RE: MP 09_0146 MOD 1 – EAST LAKES SHOPPING CENTRE

Thank you for your letter received 8 August 2017 regarding the proposed modification to the Eastlakes Shopping Centre, Eastlakes (DPE Ref: MP 09_0146 MOD 1).

4 PLAN 7th Floor  
1:100

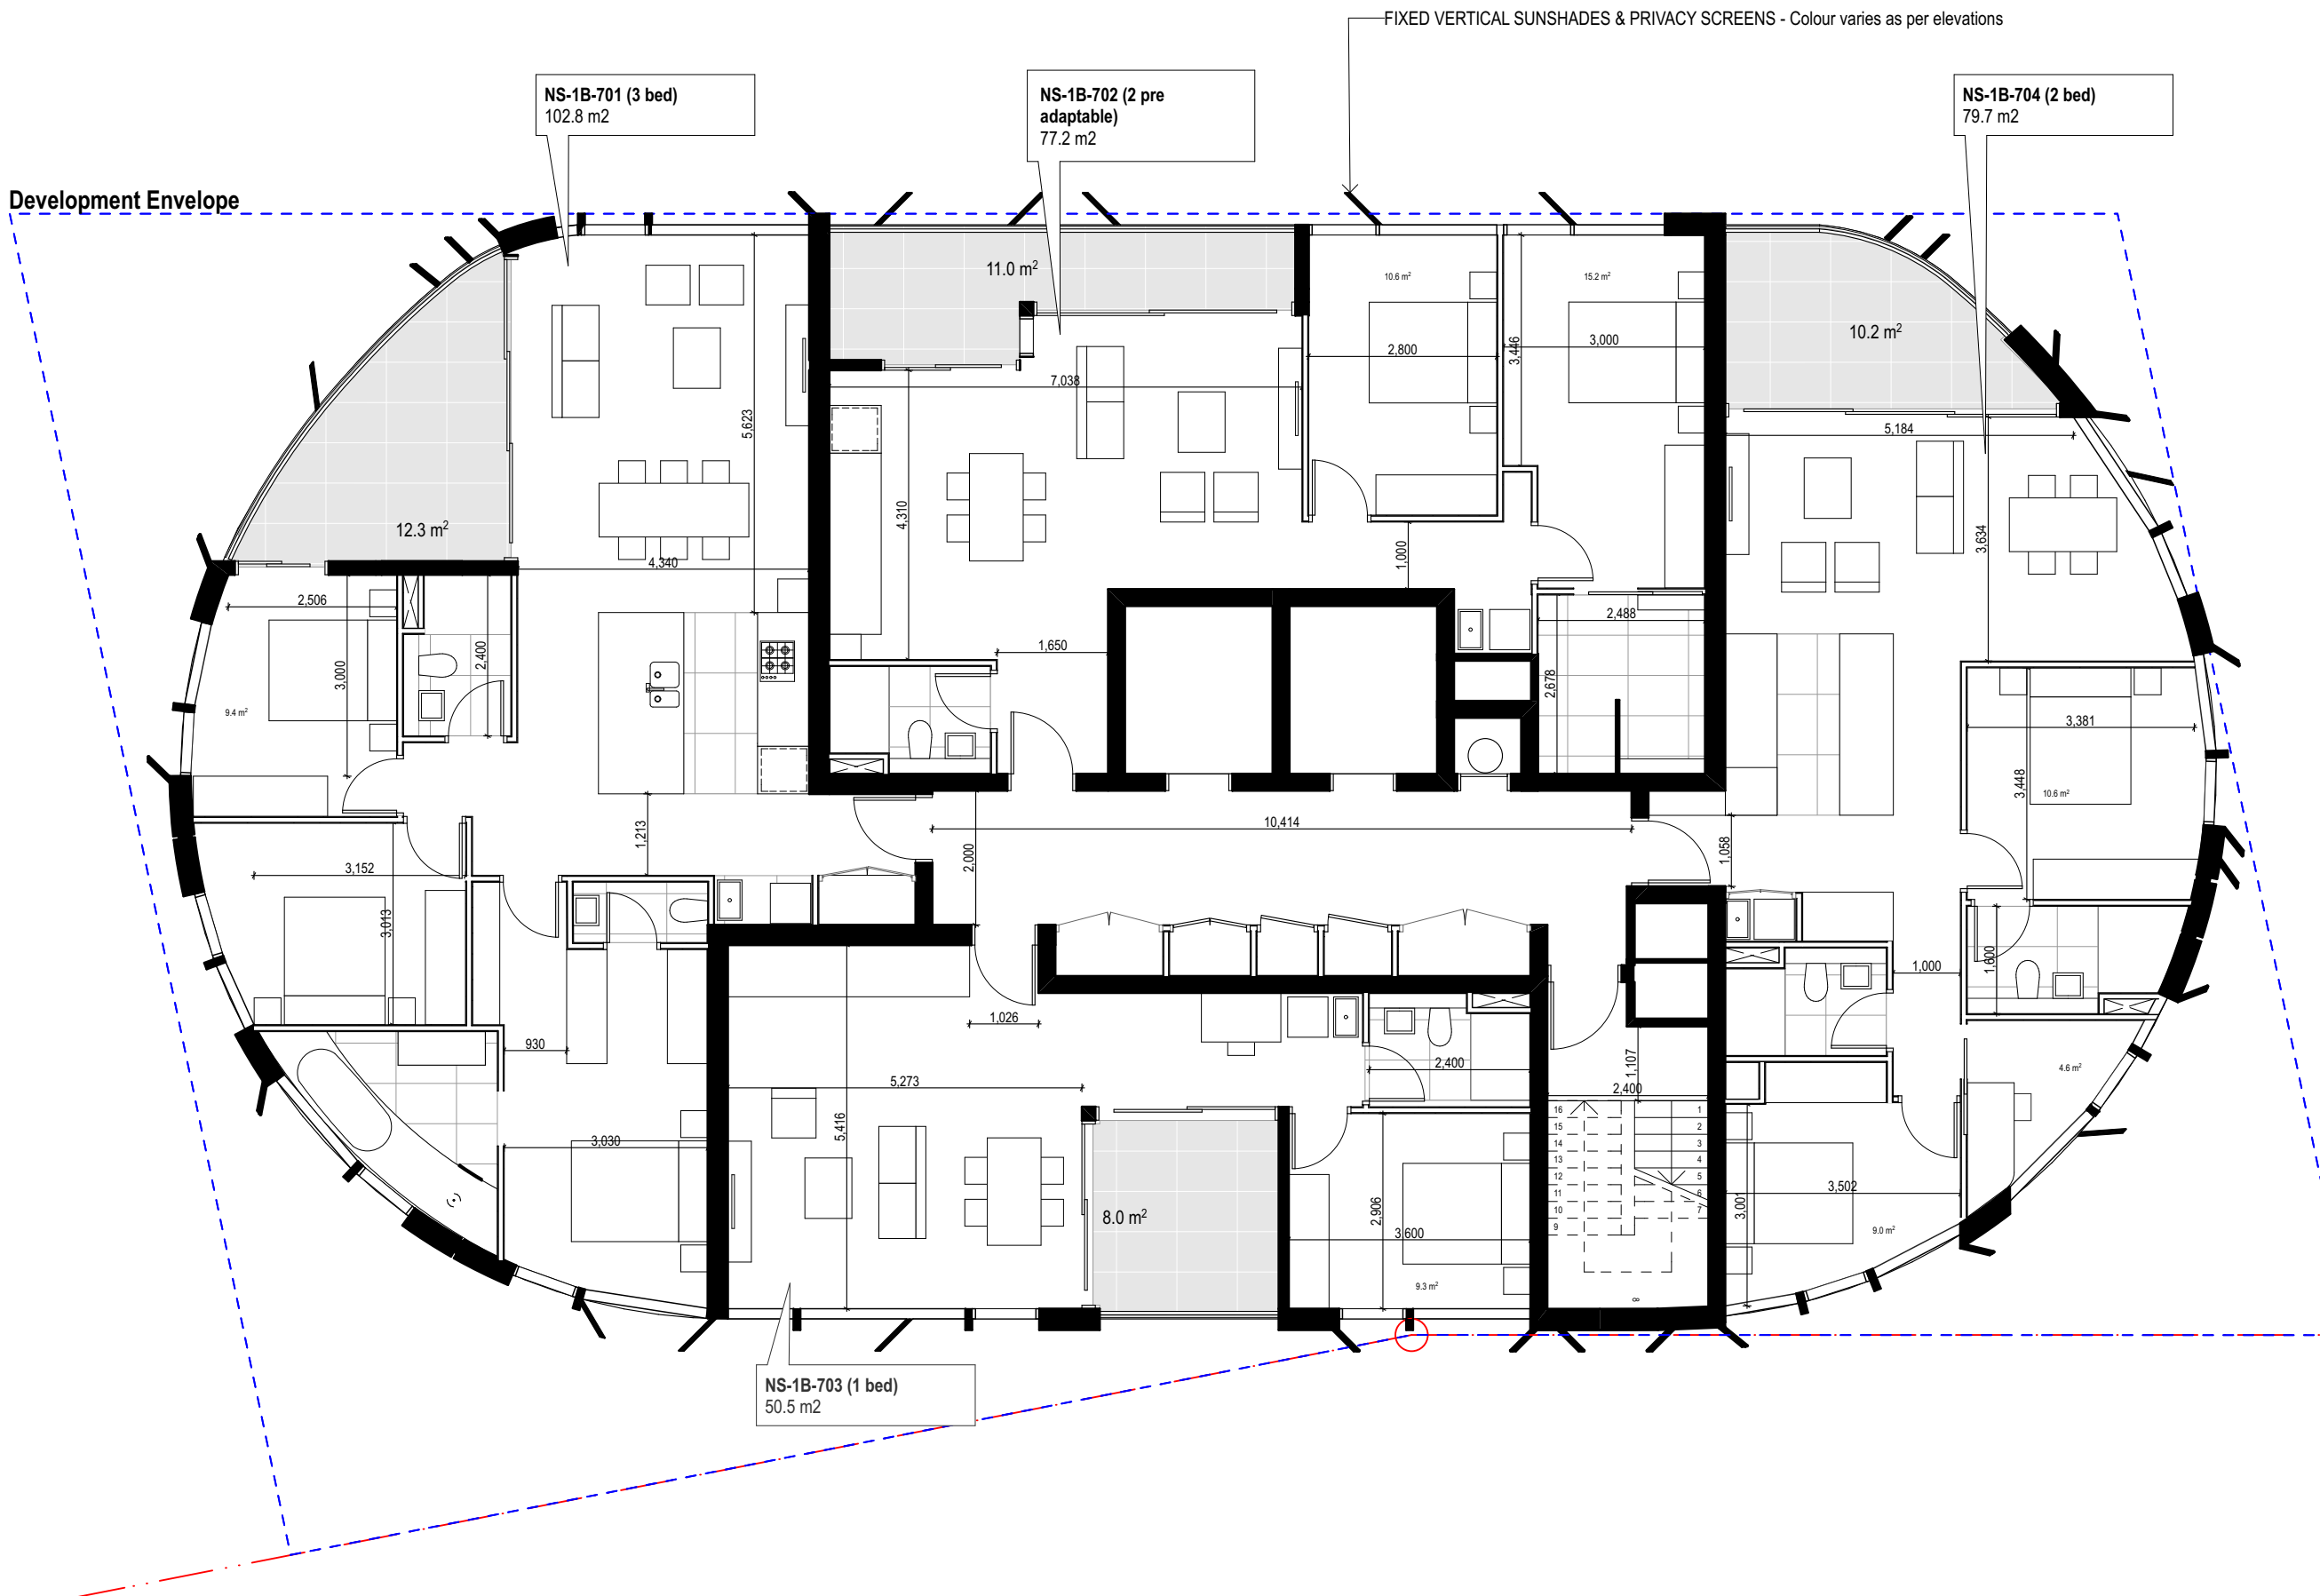
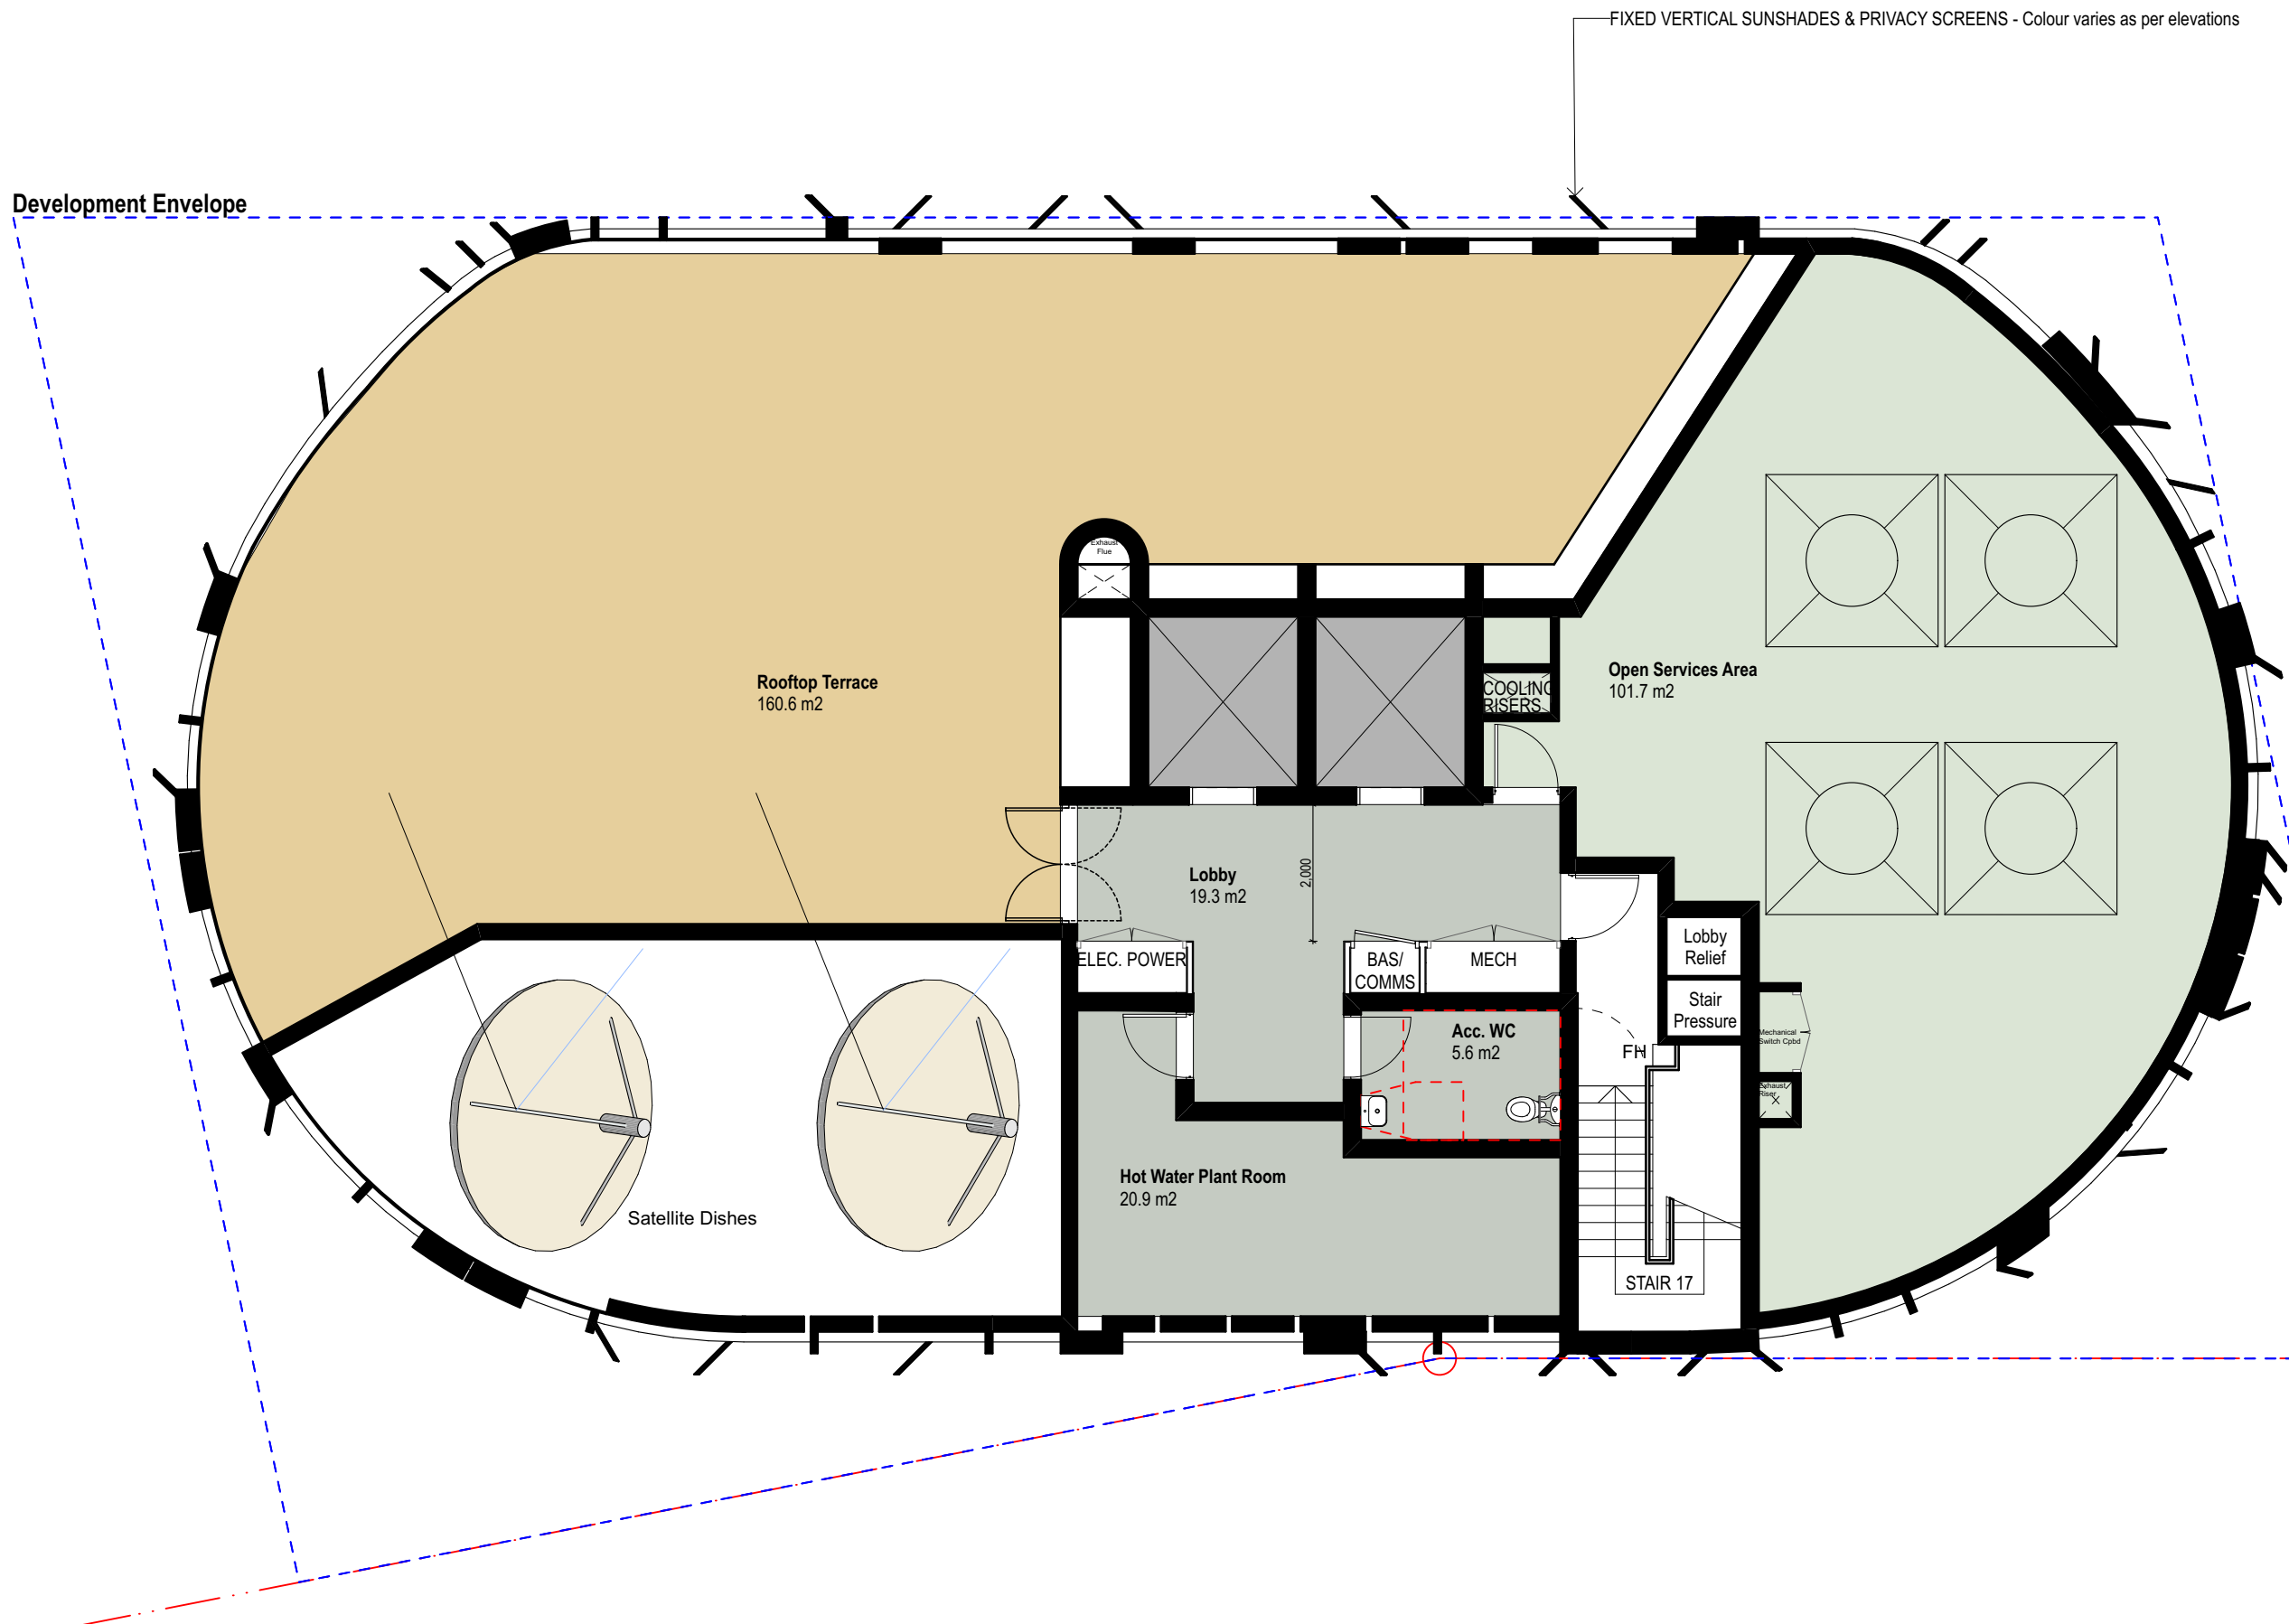
All 3-bedroom apartments in Building B1 are to demonstrate compliance with *Part 4C.4.2 - Family Friendly Apartment Buildings* of the Botany Bay Development Control Plan 2013 (BBDCP 2013).
